Your reference: SSD 5346; SSD 5347; SSD 5349
Our reference: ECM 3804935
Contact: Robert Craig
Telephone: (02) 4732 7593

State Significant Development Applications for Stages 2B and Stage 2C (SSD-5346), Stage 2D (SSD-5347) and Stage 3B (SSD-5349) of the North Penrith Mixed-Use Development.

Attachment 1

Plotted: 16 October, 2012 3:27:08 PM File Name: J:\9470\DA - Development Application Approval Plans\stage 2B-2C\9470DA20.dwg

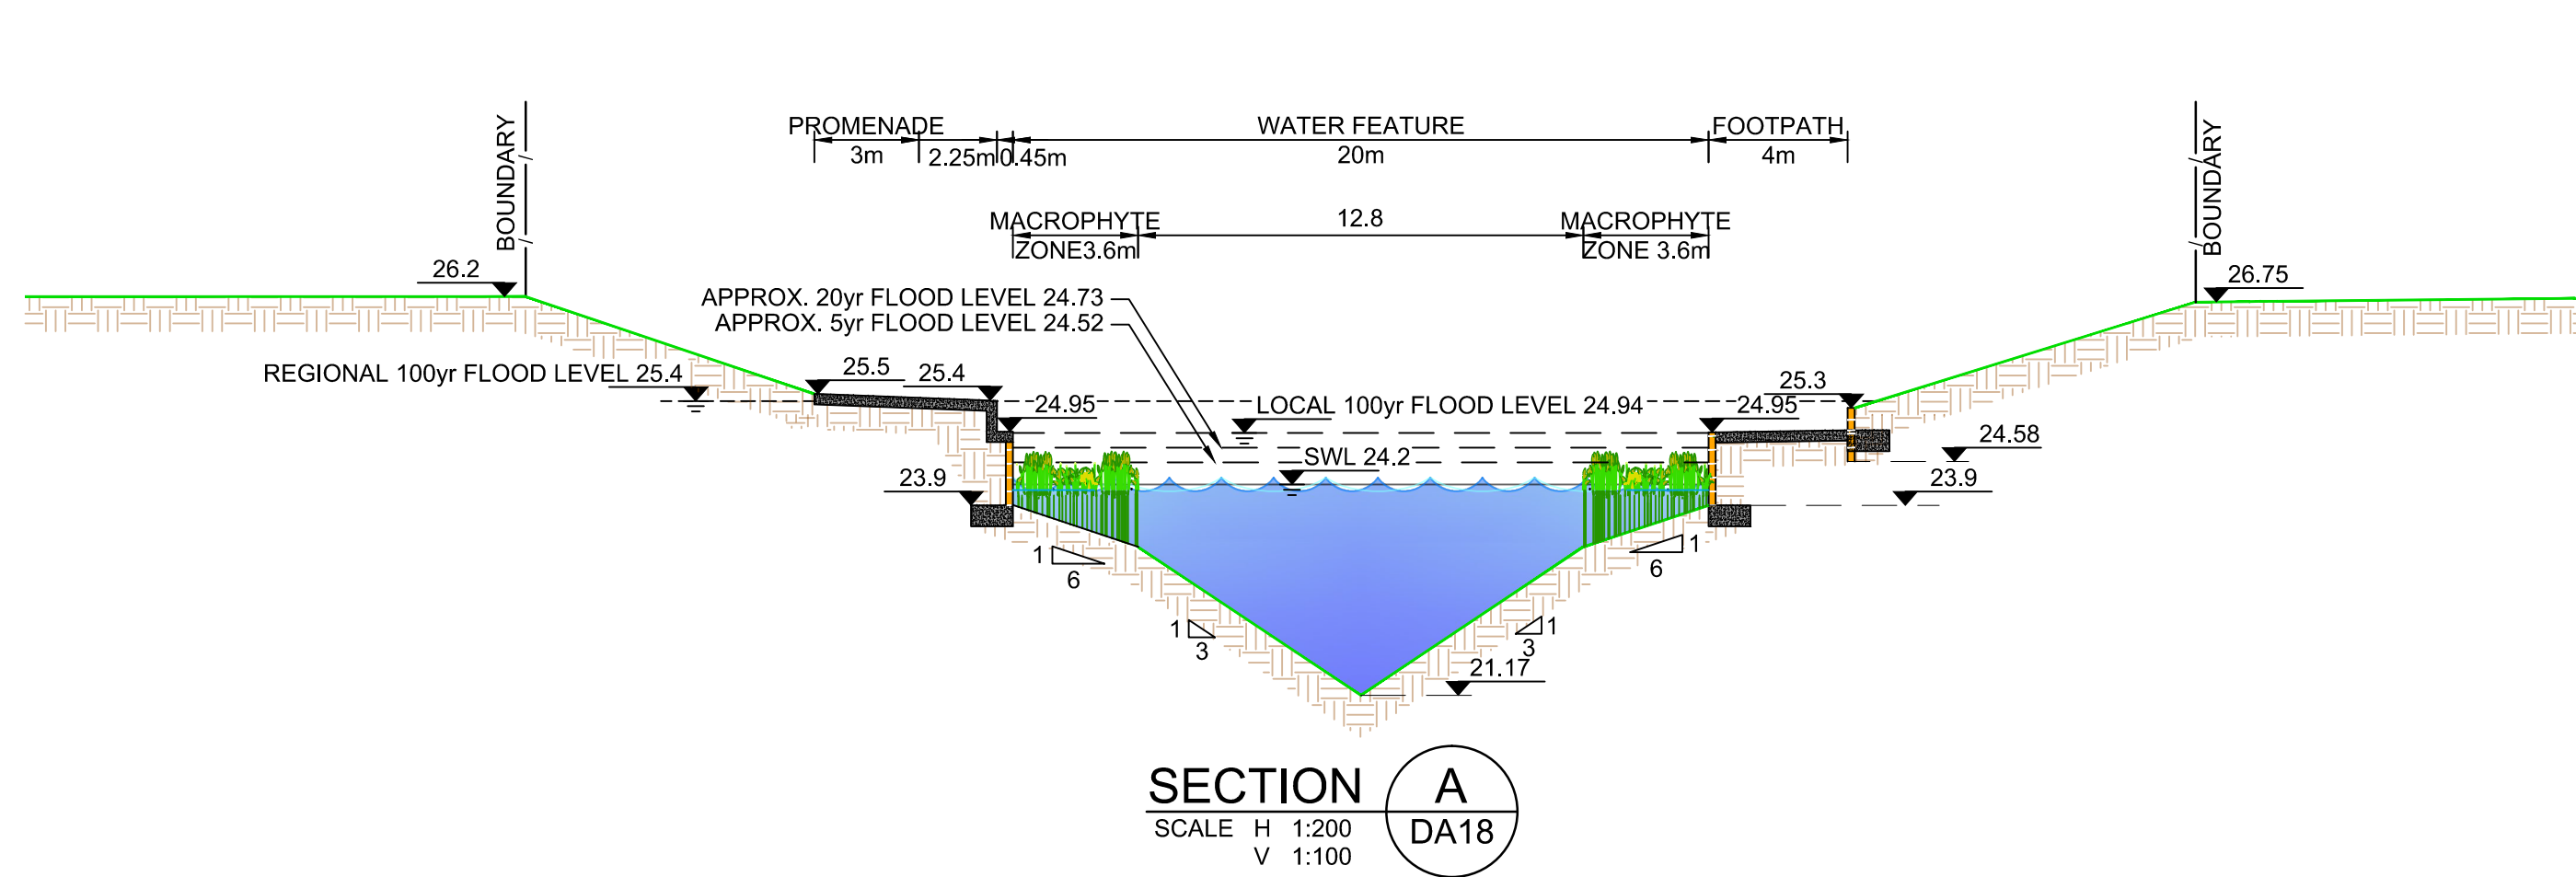
- The proposed channel is designed to provide a stormwater detention and a treatment function as well as provide some aesthetic value for the site. It is considered that the channel will have limited water quality benefits due to its design and lack of vegetation.

- There is likely to be an issue with sedimentation of the channel which will ultimately result in long term management issues with regards to algae growth. Detention ponds such as the one proposed are commonly associated with algae management and unwanted vegetation management issues. The proposed water reticulation system and reliability of aerators will be critical to the effective management of the canal and failure would likely result in management issues.

- The channel is also likely to act as a sediment basin. As such, it will be essential that adequate access be provided for maintenance and to remove sediment and other materials. Consideration for removing floating litter and other waste material should also be made during the detailed design stage and factored into the final construction of the channel.

- A detailed operational and management manual for the operation of the pumps, aerators, reticulation systems and management of the canal should be submitted to Council for approval before the handover of the assets.

<p>Public Health Matters</p>	<ul style="list-style-type: none"> ● Given the proposed recreational areas, there is the potential for temporary events involving the sale of food to be carried out. A condition in relation to temporary food stalls and mobile food vendors should therefore be imposed (see below). ● It is noted that water drinking fountains are proposed for the site. A condition should therefore be imposed to ensure that the water from these fountains is potable and the fountains are maintained in good working order and in a clean condition (see below). ● It is also noted that there will be aeration devices as part of the water feature. The applicant should consider the

<p>potential for legionella dispersal in aerosols in the construction and operation of these devices.</p> <ul style="list-style-type: none"> • Recommended conditions include the following: <ul style="list-style-type: none"> ○ The construction and operation of any temporary food outlet or mobile food vending vehicles shall be carried out in accordance with the requirements of the Food Act 2003, Food Regulation 2010, Food Safety Standards under the Australian and New Zealand Food Standards Code and the current guidelines for temporary events produced by the NSW Food Authority. Operators of temporary food outlets and mobile food vending vehicles must complete and return Penrith City Council's "Application to Sell Food" form at least 14 days prior to operating. Solid and liquid waste storage and disposal must be carried out in accordance with the Food Act 2003, Local Government Act 1993 and Protection of the Environment Operations Act 1997. ○ Drinking water fountains must be supplied with potable water in accordance with the current Australian Drinking Water Guidelines. The fountain and associated equipment must be maintained in good working order and cleaned as part of a regular cleaning schedule. ○ The water feature shall be designed and maintained to prevent the proliferation and dispersal of legionella bacteria. The aeration devices shall be designed to produce coarse water droplets to minimise aerosol formation and prevent the dispersal of legionella bacteria. The operation and maintenance plan shall include strategies for the control of legionella proliferation and dispersal.
